## Memo

**Subject** Moorebank Intermodal Site Stormwater and Flood Conditions November 2017  
**Author** Richard McManus and Mark Wainwright  
**Distribution** Department of Planning  
**Date** 16 November 2017

We have undertaken a review of Stormwater Quantity and Quality documents associated with the MPE and MPW sites. The review is presented in the following sections:

Project	MOOREBANK PRECINCT EAST (MPE) STAGE 2
Title	GENERAL ARRANGEMENT PLAN

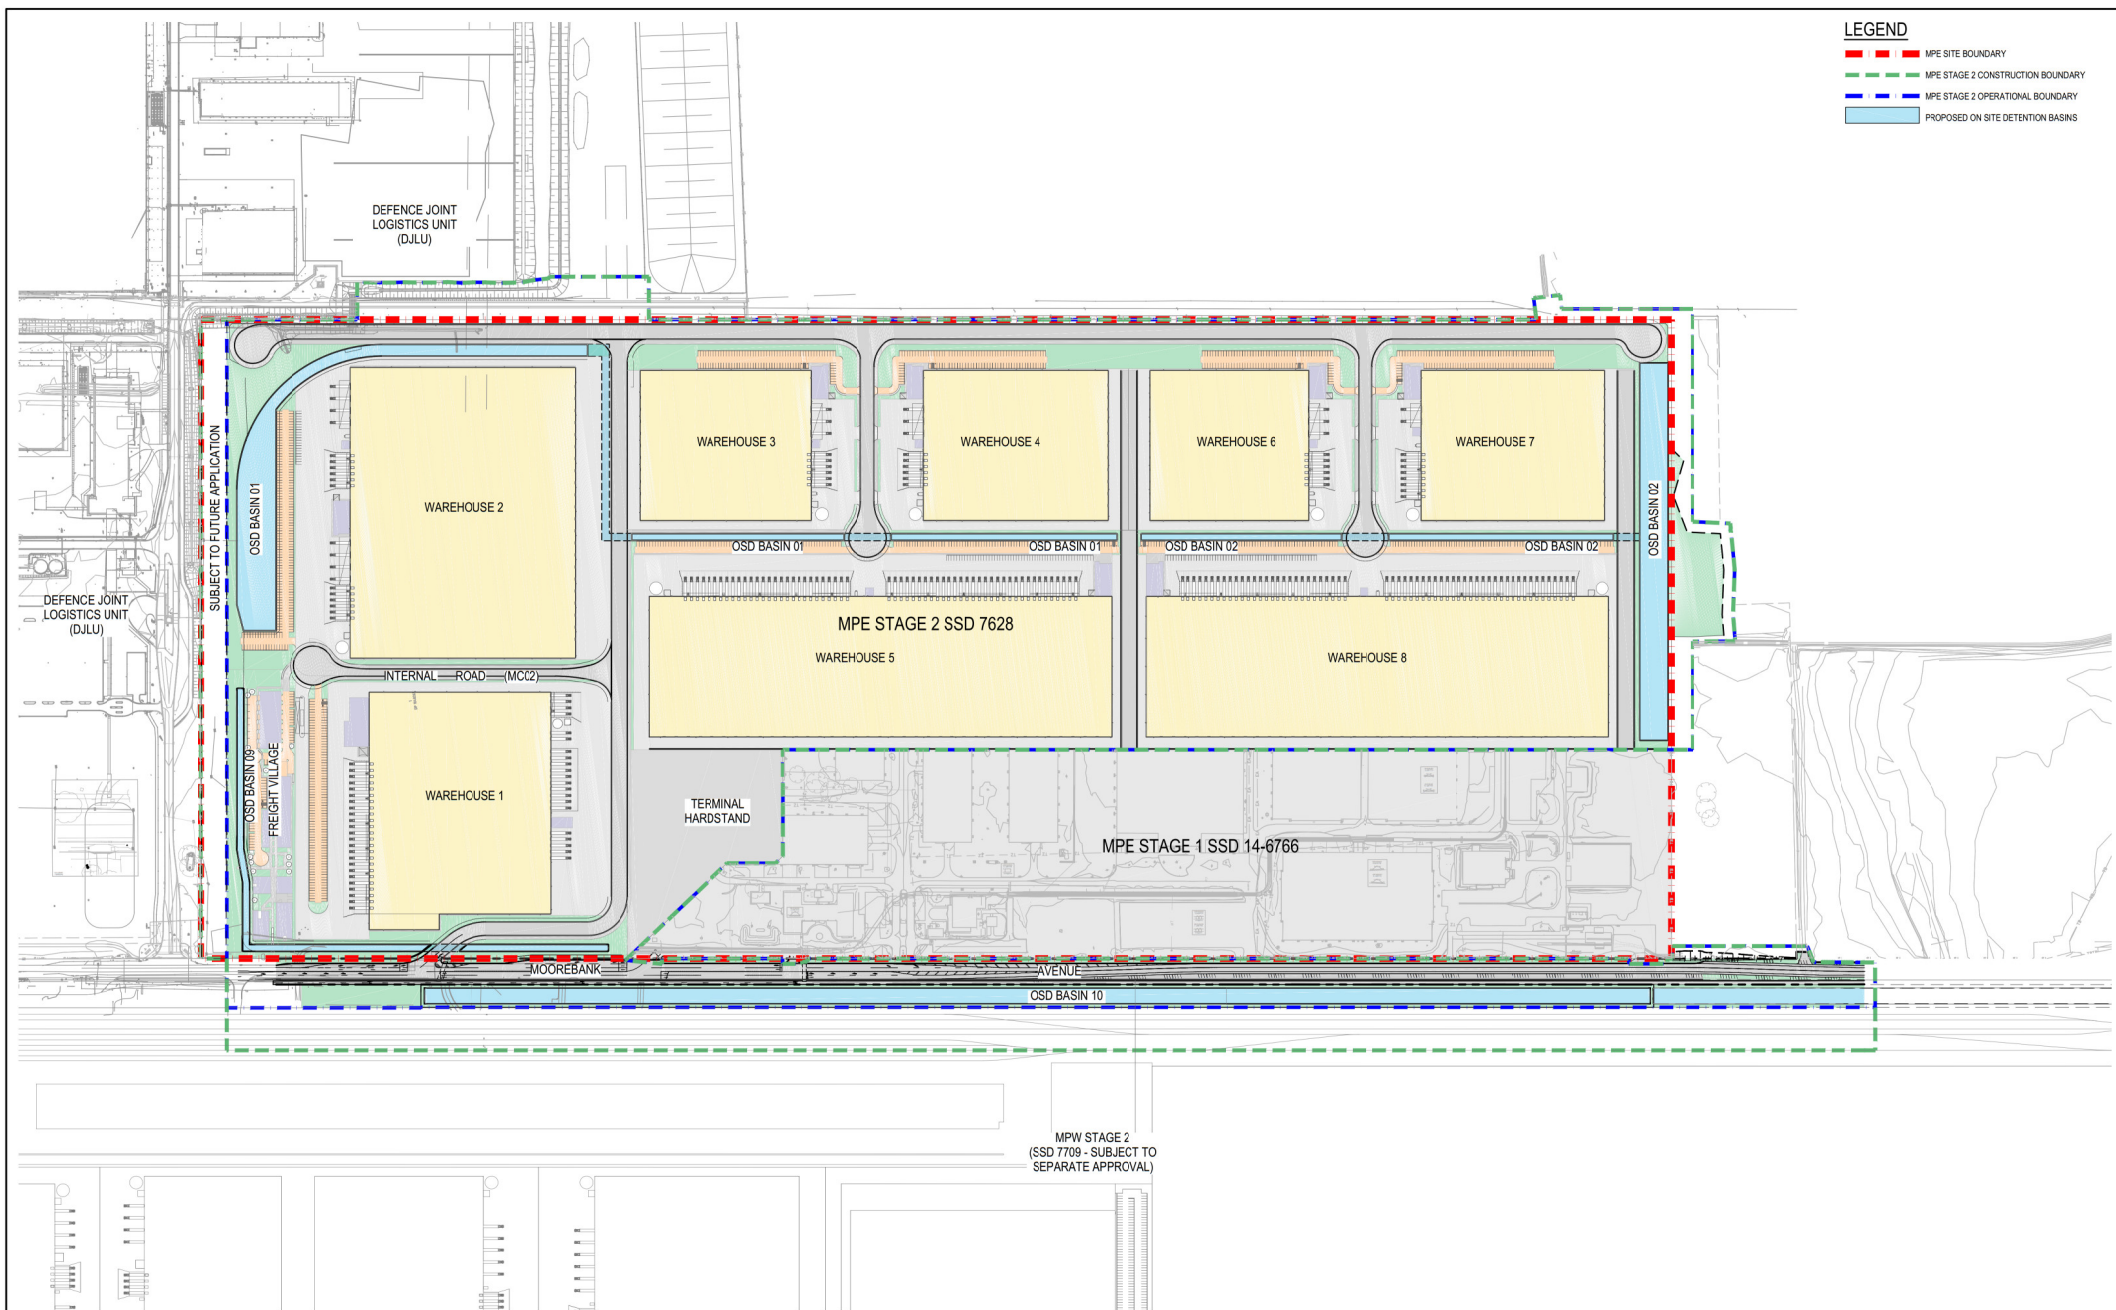
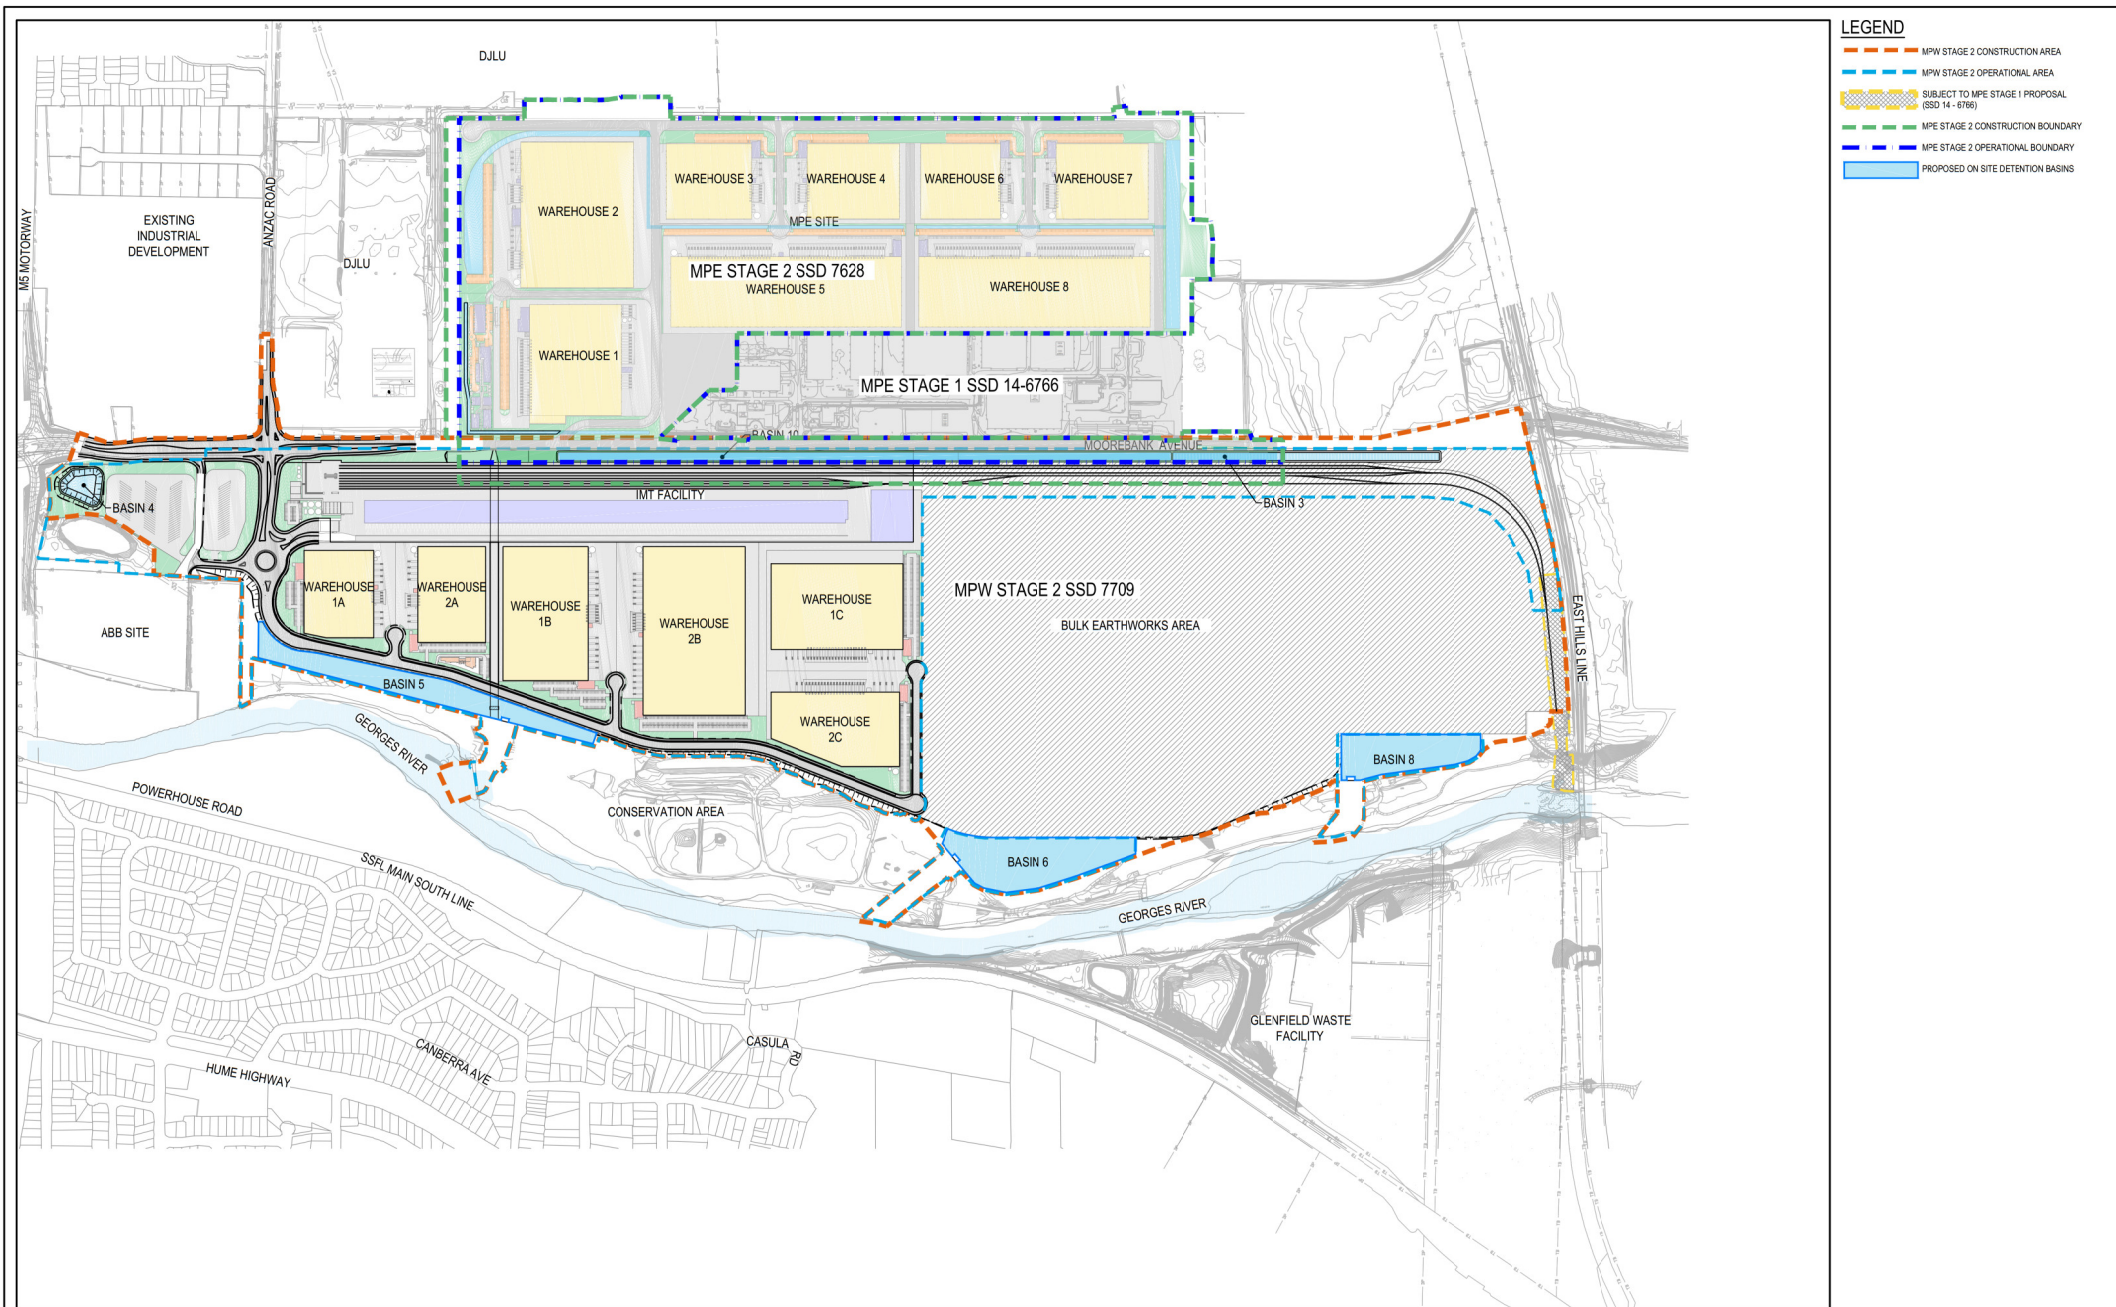
1. Updated catchment plans for the pre-development and post development conditions should be provided by the applicant for the MPW and MPE sites. These catchment plans should clearly show labelled site contours at an appropriate interval to enable the defined sub-catchments to be confirmed.

10. Proposed Basins 5 and 6 would have a maximum storage volume of approximately 60 ML and maximum water depth greater than 3m with vertical walls. The proposed basins should be assessed for consideration as "prescribed" dams under the Dams Safety Act 1978. The requirements of the NSW Dam Safety Committee for dam design should also be considered at this stage to ensure that
